M5 Junction 10 Improvements Scheme

Change Application 2 Environmental Statement Addendum TR010063 – APP 10.23

DCO Change Application Environmental Statement Addendum

Drawing Suitability						Status			
APPROVED - PUBLISHED						A1			
Project Title									
M5 J10 Improvements Scheme									
Drawing Title									
STRUCTURAL DETAILS NEW WEST CHELTENHAM LINK ROAD FLOOD ALLEVIATION BRIDGE-1 SHEET 5 OF 12

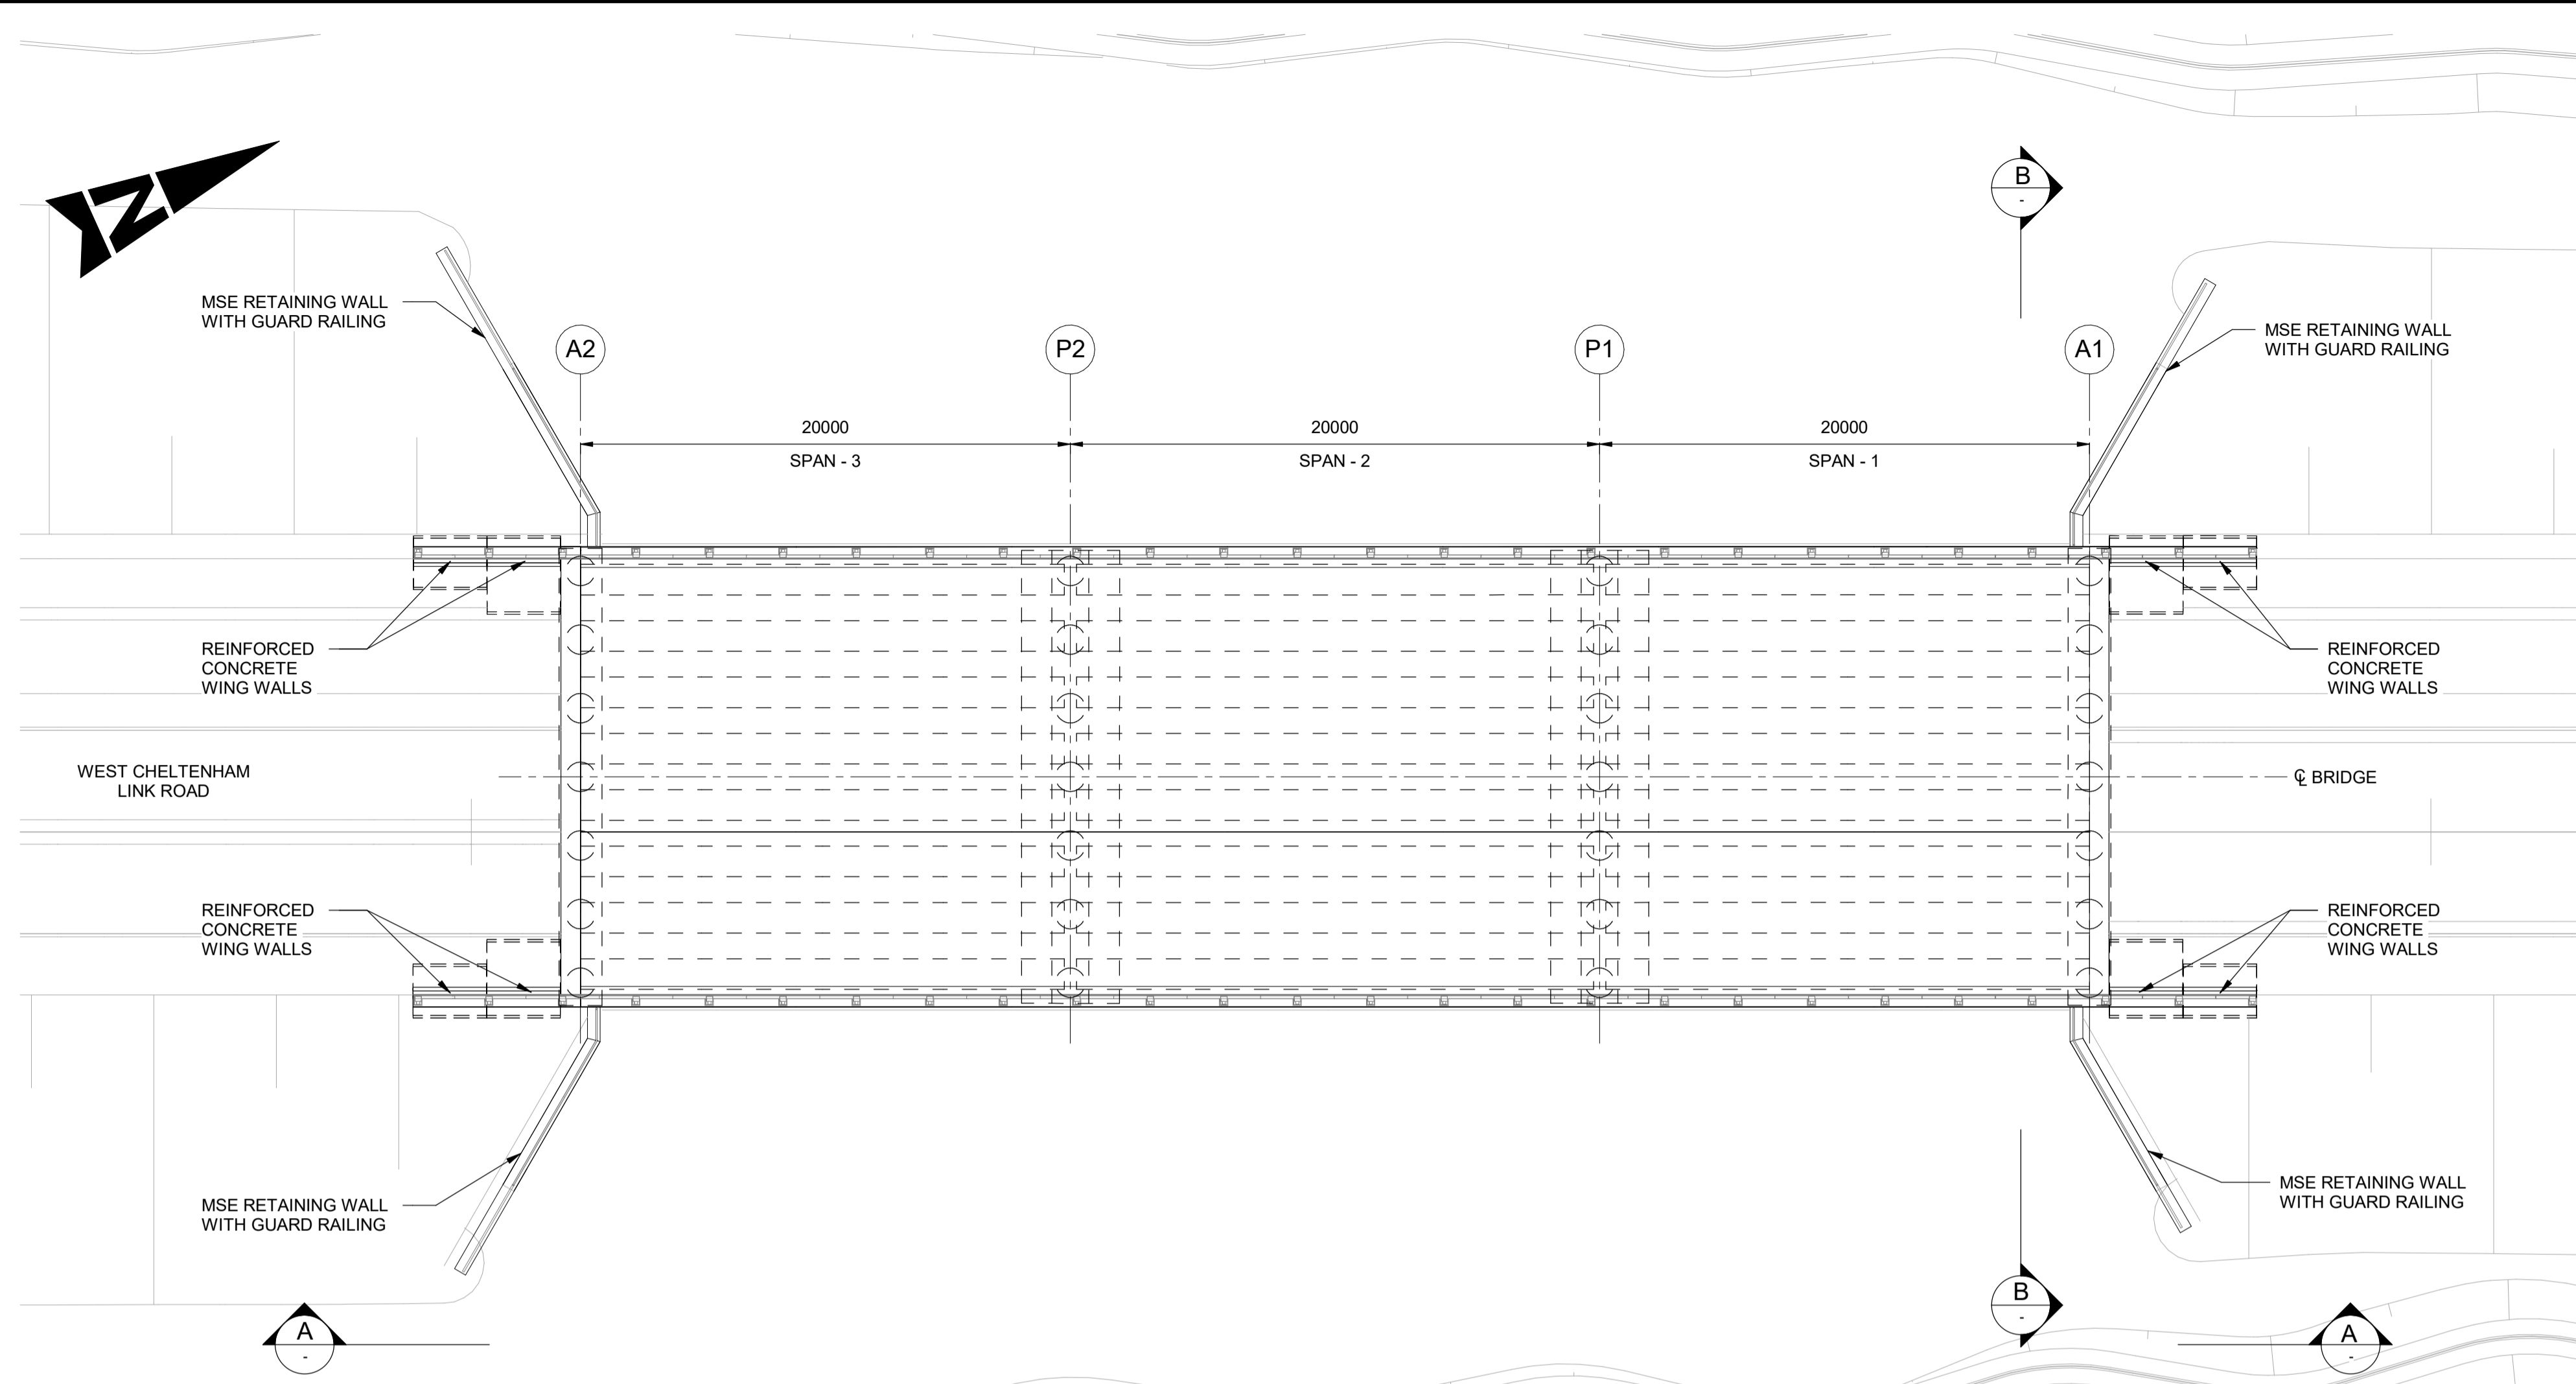
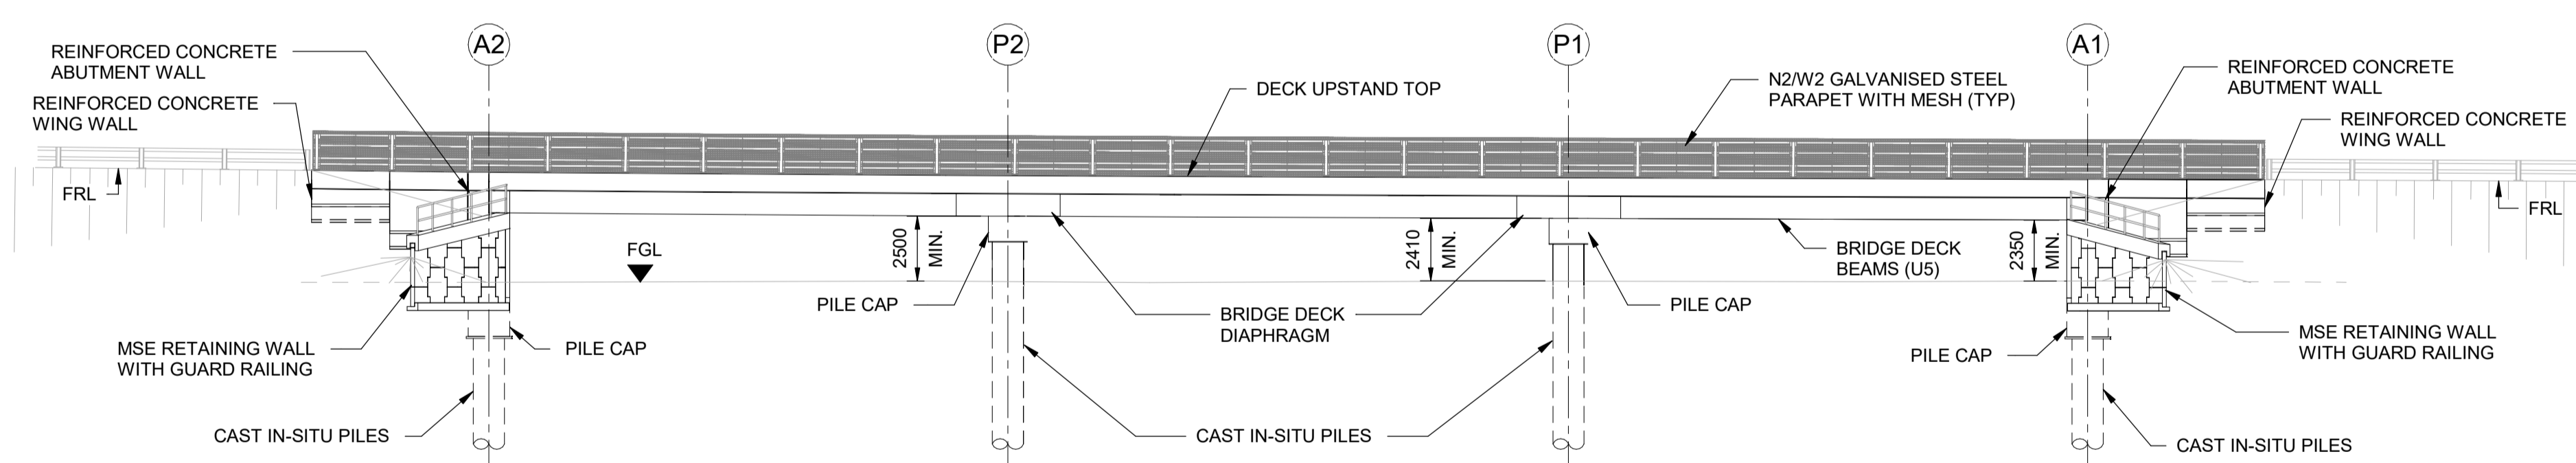
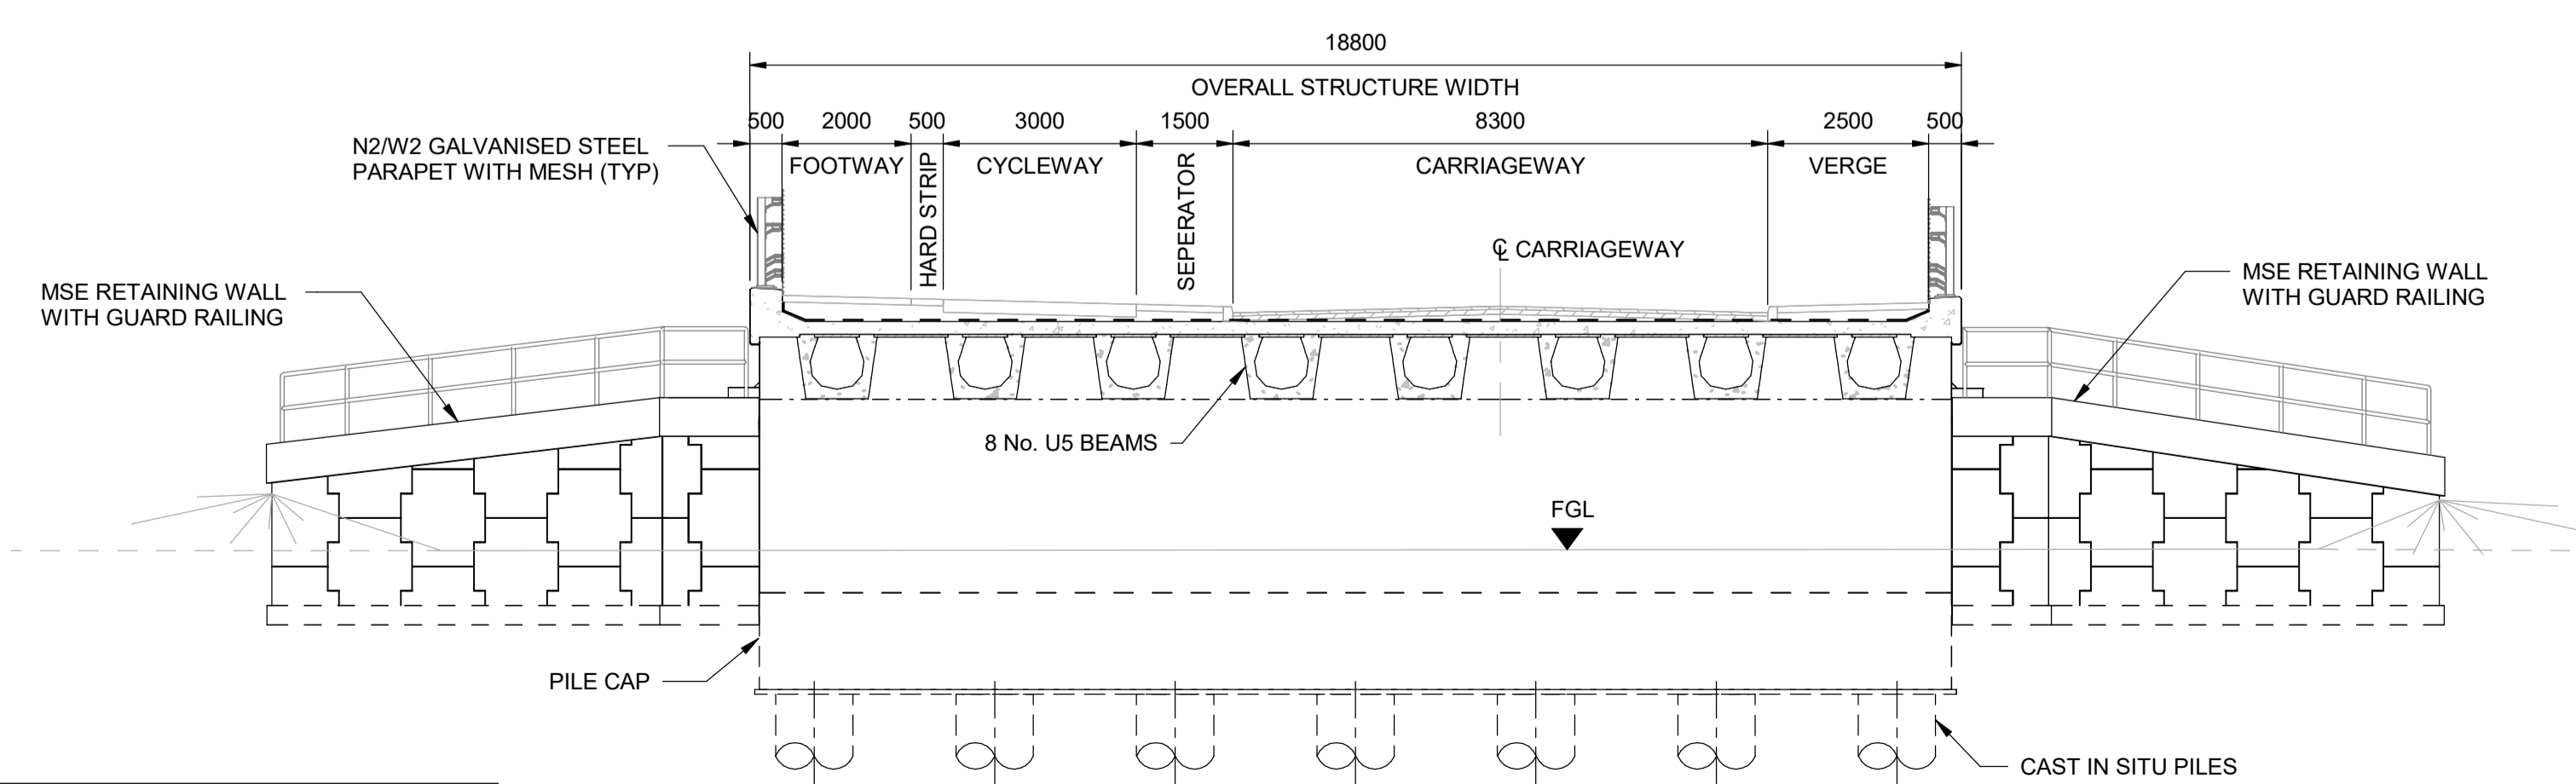
2.3.1. In the Scheme submitted as part of the DCO application, the flood alleviation structures on the Link Road consist of two sets of culverts constructed from pre-cast units. The change is to improve this arrangement by changing the structural form of this flood conveyance from culverts to bridges. The change is shown in Structural Details – New West Cheltenham Link Road Flood Alleviation Bridge 1 Sheet 5 of 12 and Structural Details – New West Cheltenham Link Road Flood Alleviation Bridge 2 Sheet 6 of 12.

- 2.3.2. The change will reduce risk in the construction programme, reduce the potential for construction impacts on the floodplain, and improve the structural performance of the structure. The change will also provide minor improvements in ecological connectivity and the passage of floodwater.
